MESA DEL SOL
ARCHITECTURAL CONTROL COMMITTEE
SITE DEVELOPMENT PLAN REVIEW

**RE: Mesa Del Sol Self Storage
5500 Turing Dr. SE
Grading and Drainage Plan
Engineer's Stamp Date: 5/7/2025
Hydrology File: R16DA1004**

**Re: Mesa Del Sol Self Storage
 5500 Turing Dr. SE
 Grading and Drainage Plan
 Engineer's Stamp Date: 01/15/2025
 Hydrology File: R16DA1004**

Here are the responses to the comments provided on March 21, 2025 in regards to an **Updated Grading & Drainage prior to continuing onsite grading and foundation work.**

SHEET NUMBER

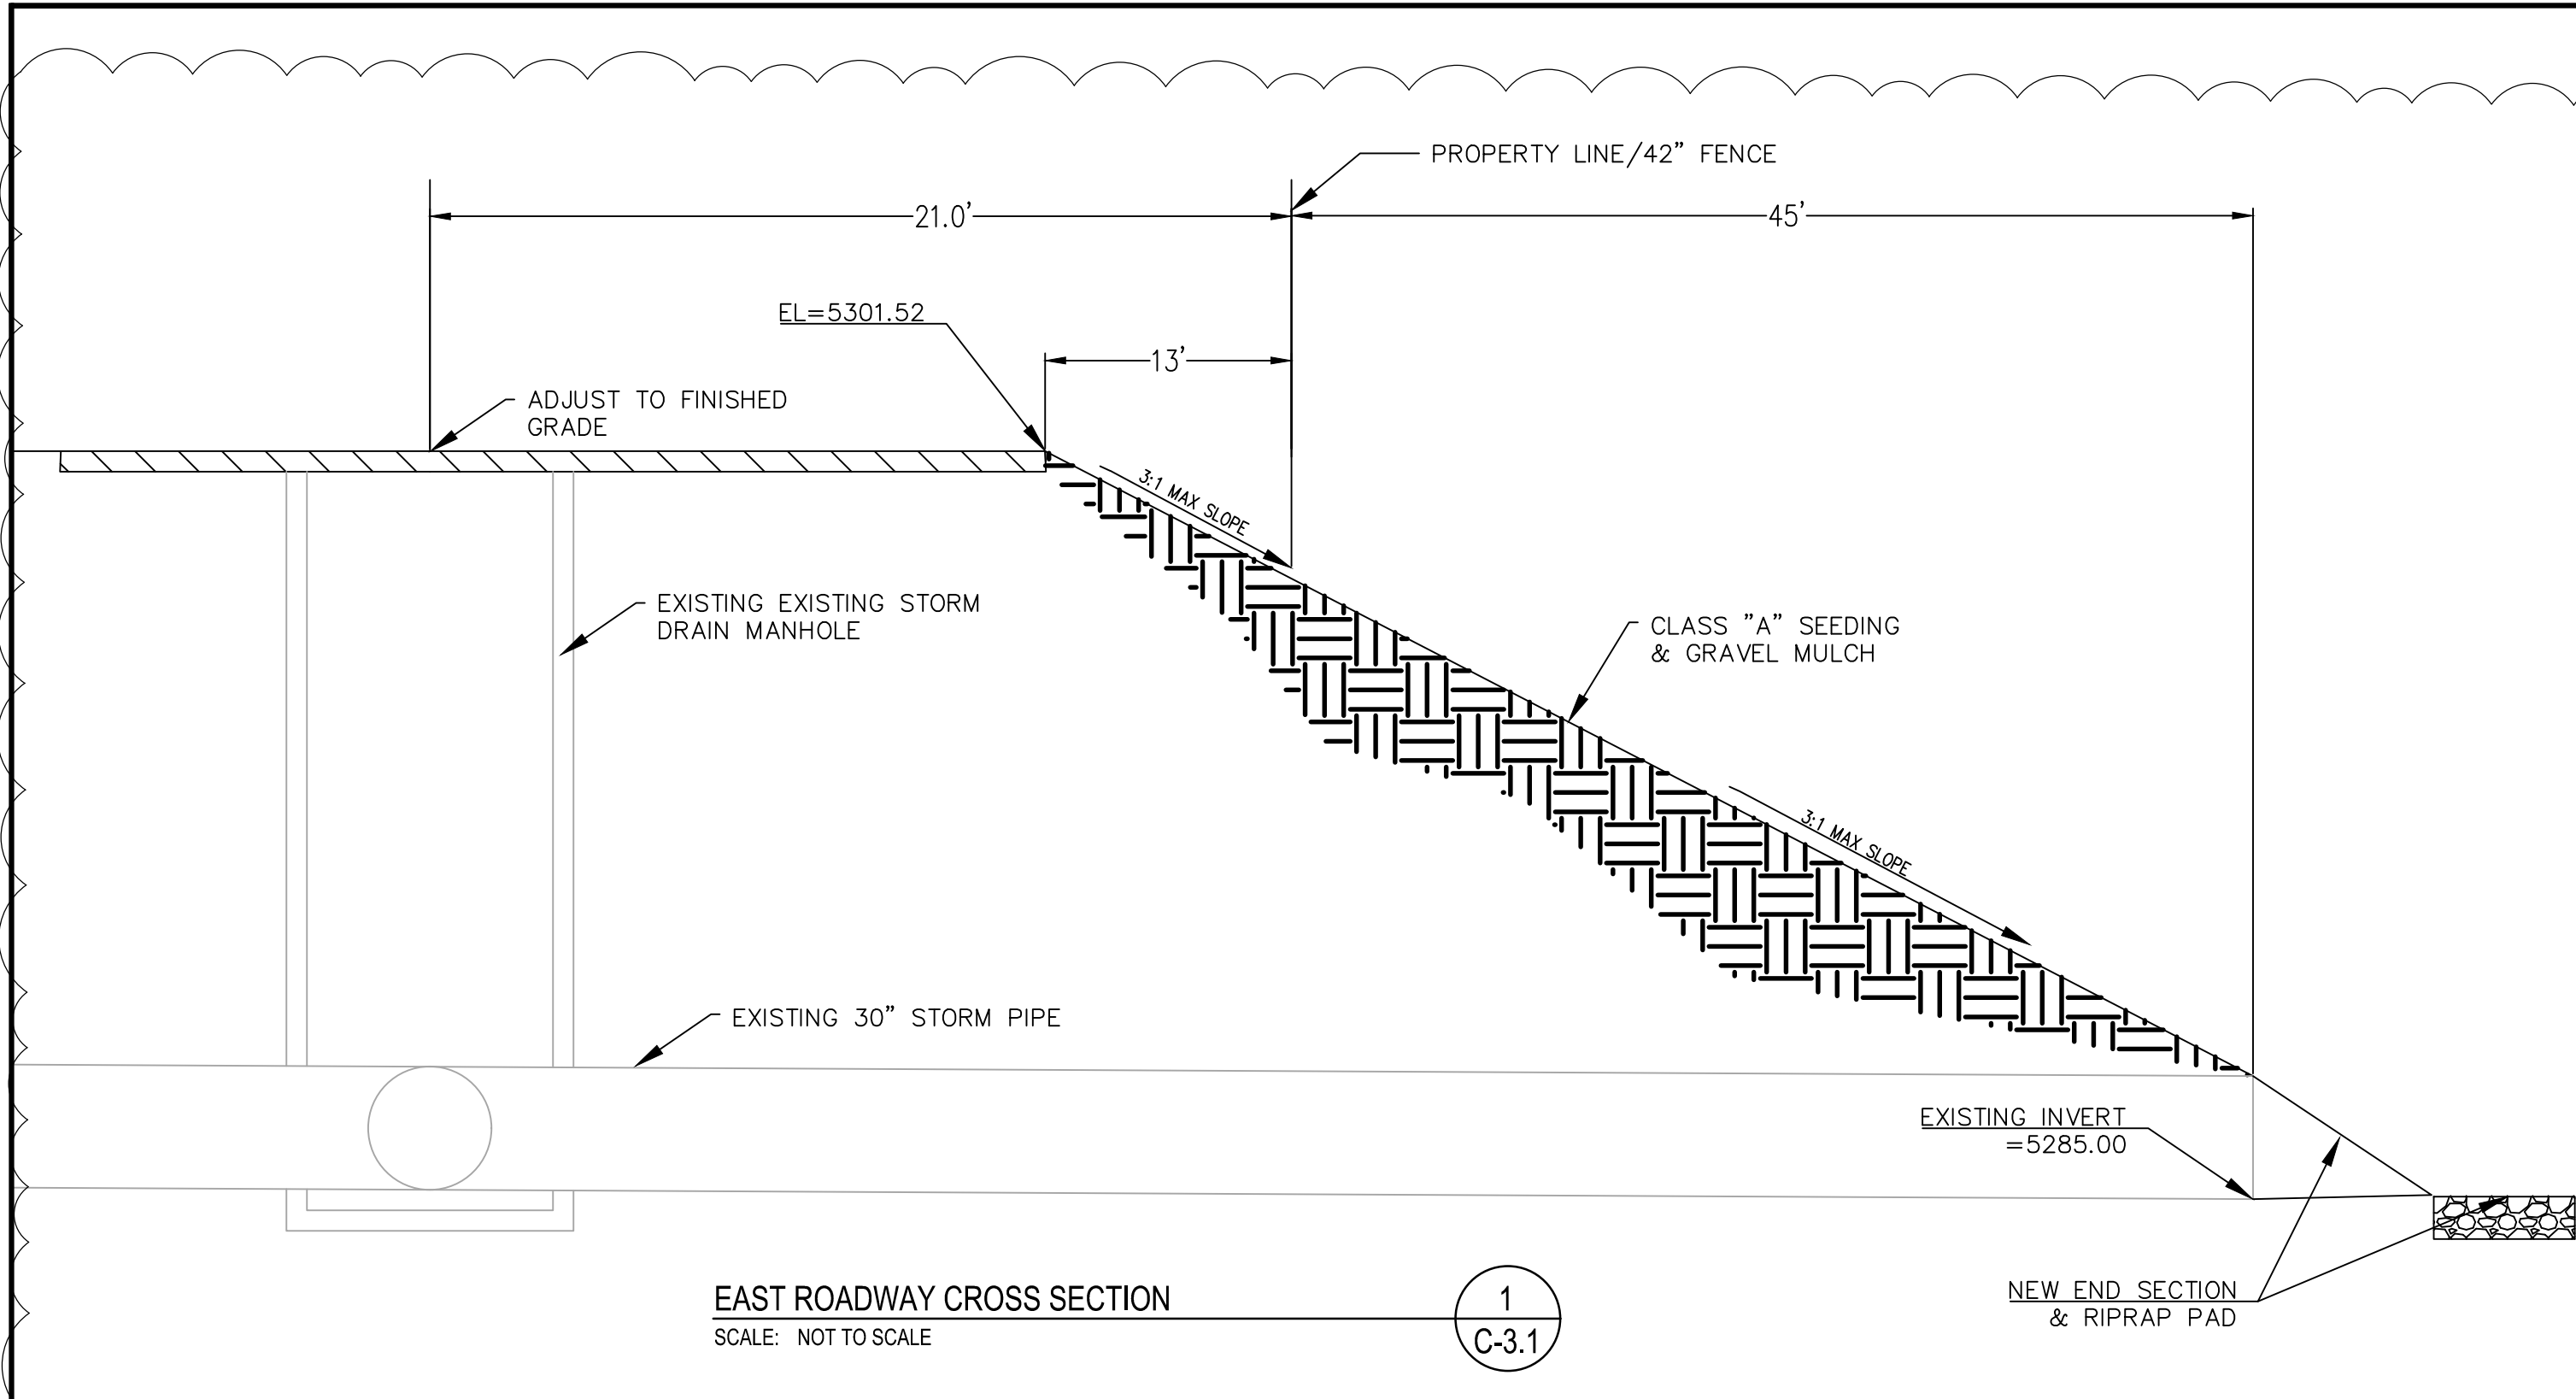
8. Due to the proposed retaining wall in Section 1 of C-3.1, provide an additional cross-section showing the existing storm drain manhole and pipe extension through the proposed retaining wall and into the retention basin at the southeast corner of the project.
Concur. Additional section has been added, see revised sheet C-3.1 & C-3.2. Retaining wall removed from revised design.
